**2023/1114**

**Address:** 25 Norwood Drive, Brierley, Barnsley S72 9EG

**Description:** 2 storey side extension to detached dwelling

PROPOSED FRONT ELEVATION  
SCALE 1:100 AT A3

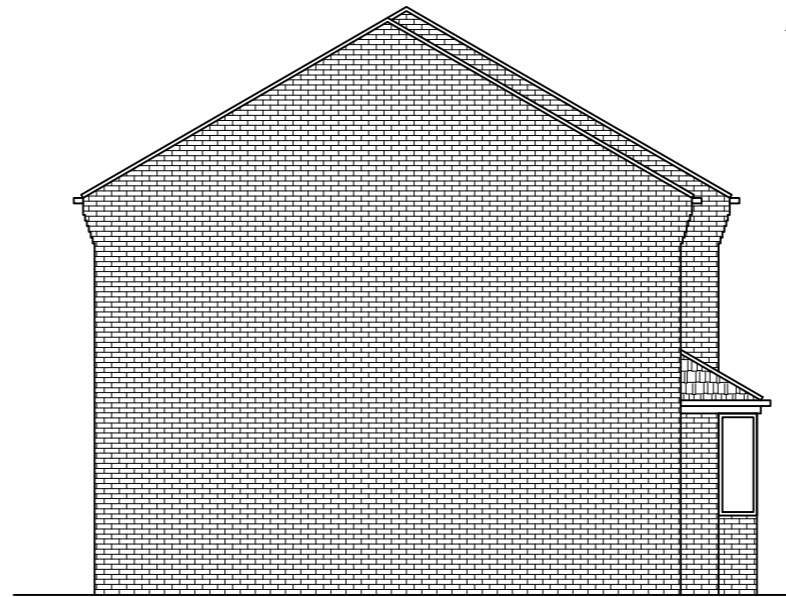
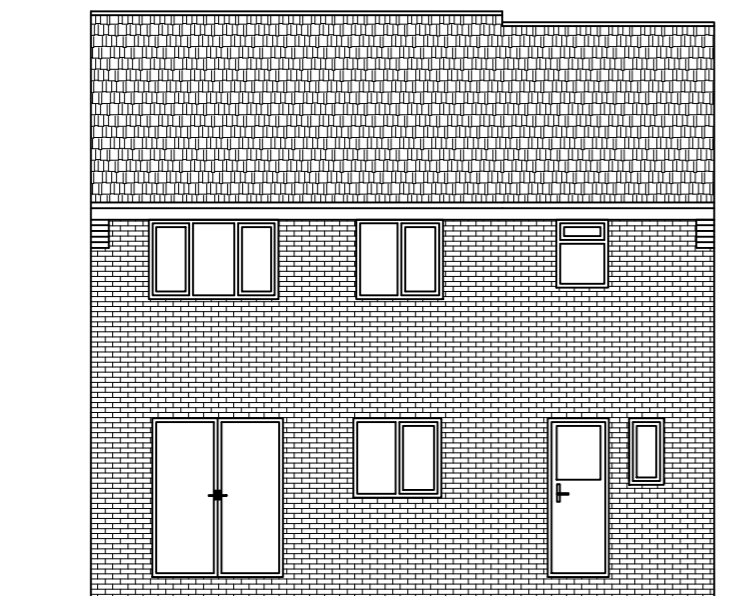
The extension now incorporates a small setback of 50cm, on both the ground and first floor level, in addition to a set down roof. Together with the setback and set down, the use of matching/similar materials will ensure the extension looks both subordinate in relation to the original dwelling but also not significantly out of character with it, meeting guidance outline in the House Extensions and Other Domestic Extensions SPD. Some dwellings on the street, for example No.33 and No.41 both feature integrated garages, so the proposed character of the dwelling would also not be significantly out of character with the street scene.

PROPOSED GROUND FLOOR PLAN
SCALE 1:100 AT A3

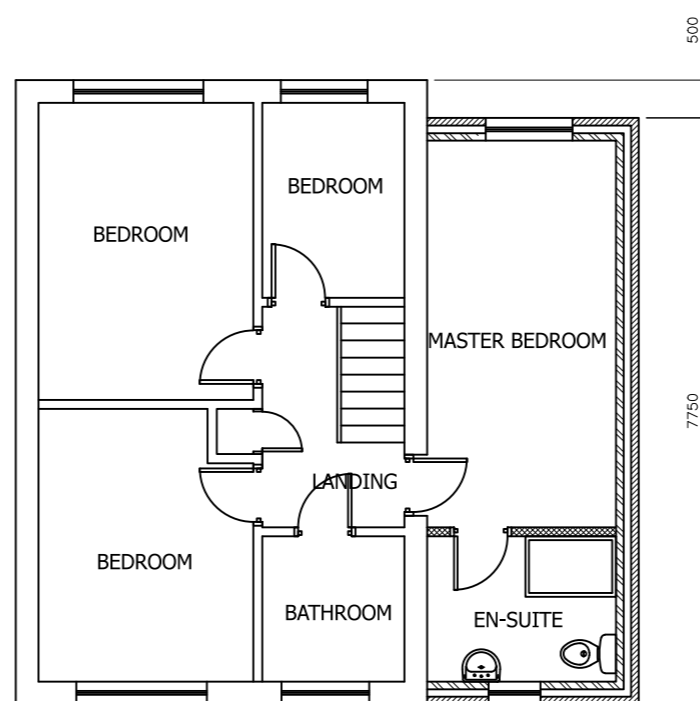
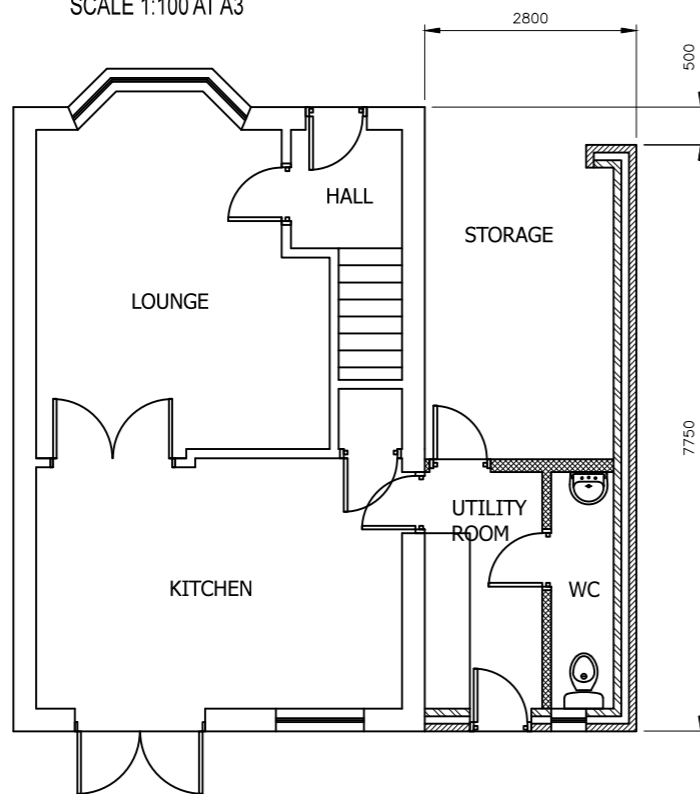
The proposal is for a two-storey side extension located on the left side elevation (when viewed from the road). The ground floor would feature a garage area used for storage, as it would not meet the size standards parking a vehicle, with a WC and utility room to the rear. Both the first floor and after highways consultation, ground floor, as indicated within the site plan would be set back. The first floor would feature a new master bedroom and ensuite. The proposed roof would be of gable style, set down to match the original house, with a small canopy frontage to match the existing front canopy.

**Highways DC:** Highways initially objected to the proposal on the grounds of insufficient parking within the curtilage of the dwelling, with the new garage (storage area) not being suitable for vehicle parking. Following discussion, a revised plan with the new garage (storage space) to be open, and two parking spaces to be provided was accepted by Highways. Following a revision by the applicant, the proposed extension would now not be open, but instead set back to allow two highways standard size parking spaces to be installed, one to be situated in front of the garage and another within the dwelling's front curtilage. Despite meeting Highways standards for parking space size, the forecourt size requirements for parking spaces in front of a garage was not met. However, in this instance and subject to conditions, Highways agreed that in the proposals were satisfactory and withdrew their objection.

SITE PLAN  
SCALE 1:500 AT A3

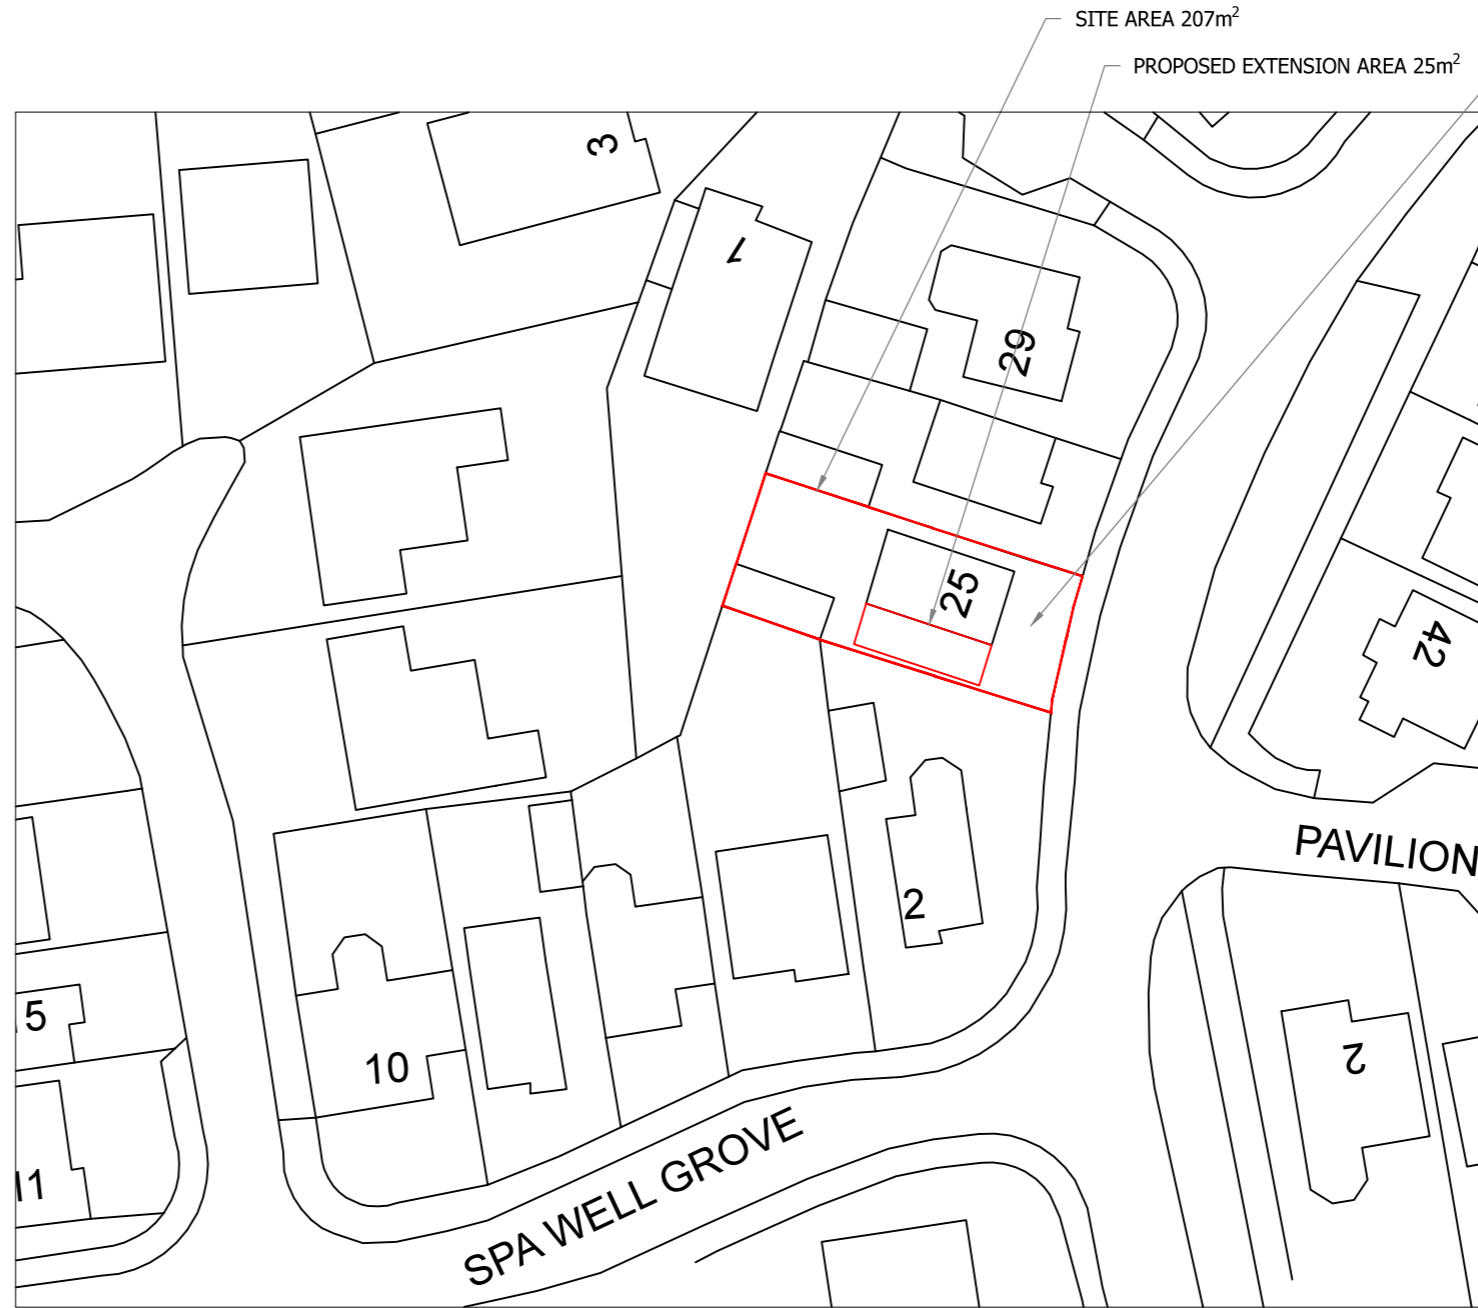
Following an initial objection by Highways for inadequate parking provision, a final solution has been deemed acceptable, which allows two vehicles to be parked within the curtilage of the dwelling. To ensure parking in front of the garage remains viable, a condition for a roller garage door has been requested. With the objection removed, there are no issues in relation to highway safety.
